Structural Clarification Item

Project: StruXure - McArthur
8609 SE 78th St
Mercer Island, WA 98040

Re: Building Jurisdiction Comments

Reference signed and sealed aluminum pergola design dated May 27, 2022:

DESCRIPTION	SECTION A-A
DATE	05/06/22
DRAWN BY	I&S
SCALE	3/8" = 1'-0"
SHEET NO.	A 201

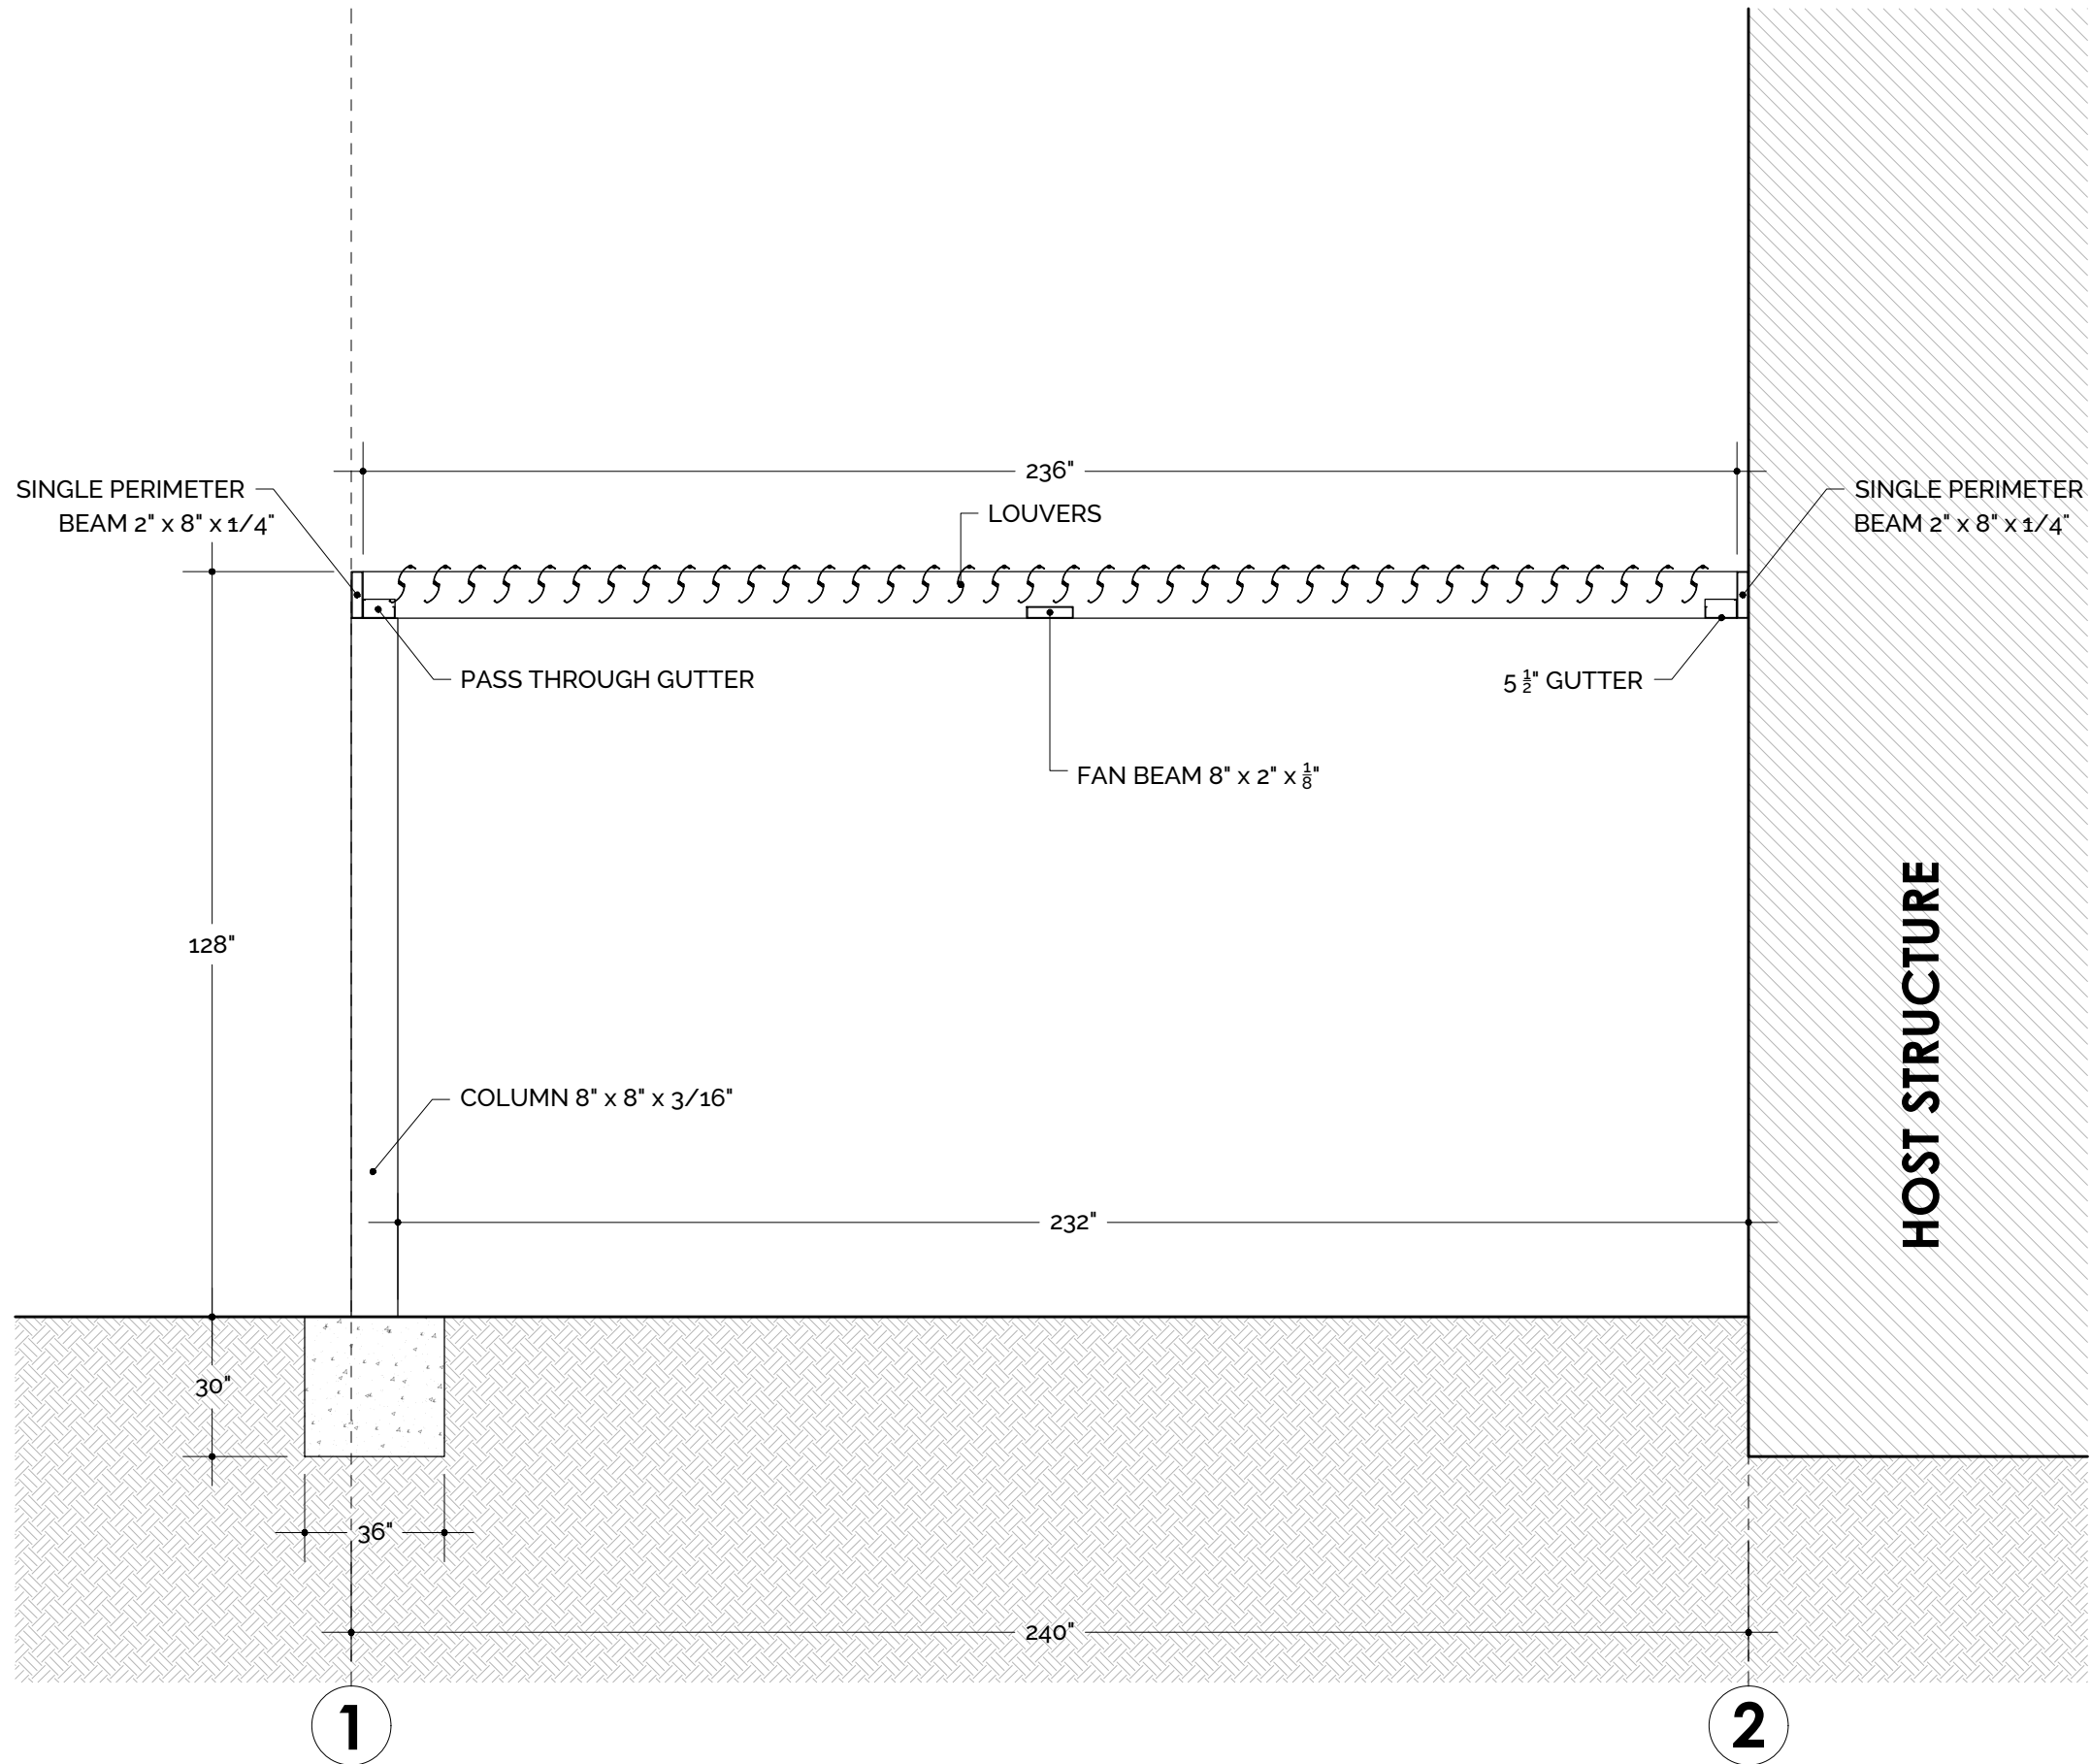
- 3.) EEPC has analyzed the existing structure for the additional loading of the host structure.
 3. *An analysis of host structure applied loads provide justification that house structure can properly handle design load referenced on last page of structural package.*

DESCRIPTION	DETAILS
DATE	05/06/22
DRAWN BY	I&S
SCALE	N.T.S.
SHEET NO.	A 307

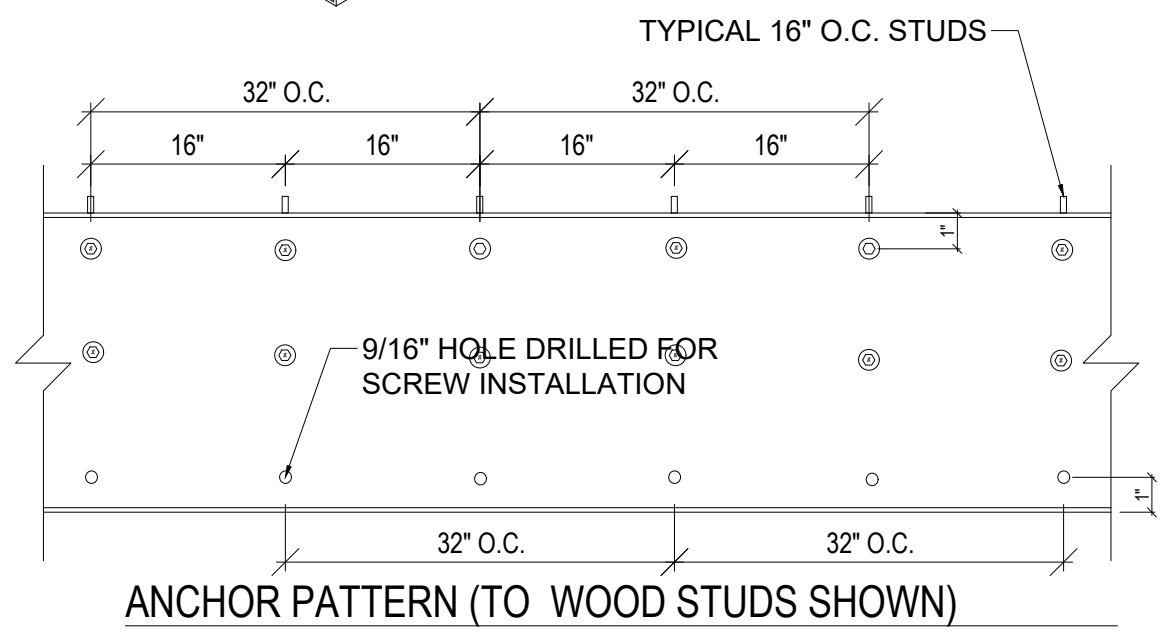
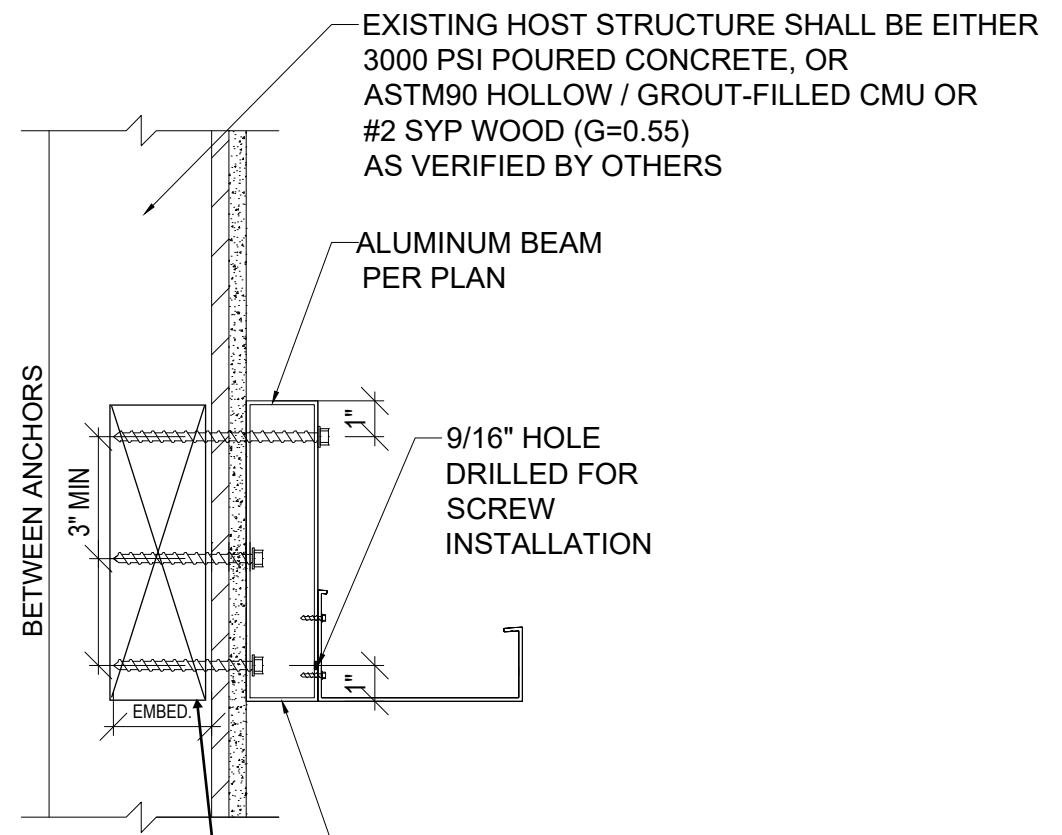
- 1.) Eclipse Engineering, P.C. (EEPC), has provided fastener calculations for a 2" distance between blocking and the screw head.
 1. *Provide Max distance between blocking and head of screw to be considered in design*

- 2.) EEPC has provided calculations for a new ledger/blocking with a minimum thickness of 1-1/2".
 2. *Verify that there is a 3" of embed depth in ledger of the house to comply w/the detail and designed and calculated.*

- 4.) EEPC determined new blocking must be installed between host studs to provide ledger connections at the proposed pergola height of 10'-0".
 4. *Provide actual height of the attachment detail to engage with blocking provided in detail A/307. Concern of existing ledger or bottom plate to actually engage.*

RECOMMENDED: (2) SIMPSON SDS25134 SCREWS @ 16" OC, BTM & (1) SIMPSON SDS25134 SCREW @ 8" OC, TOP W/ BLKG BETWEEN STUDS
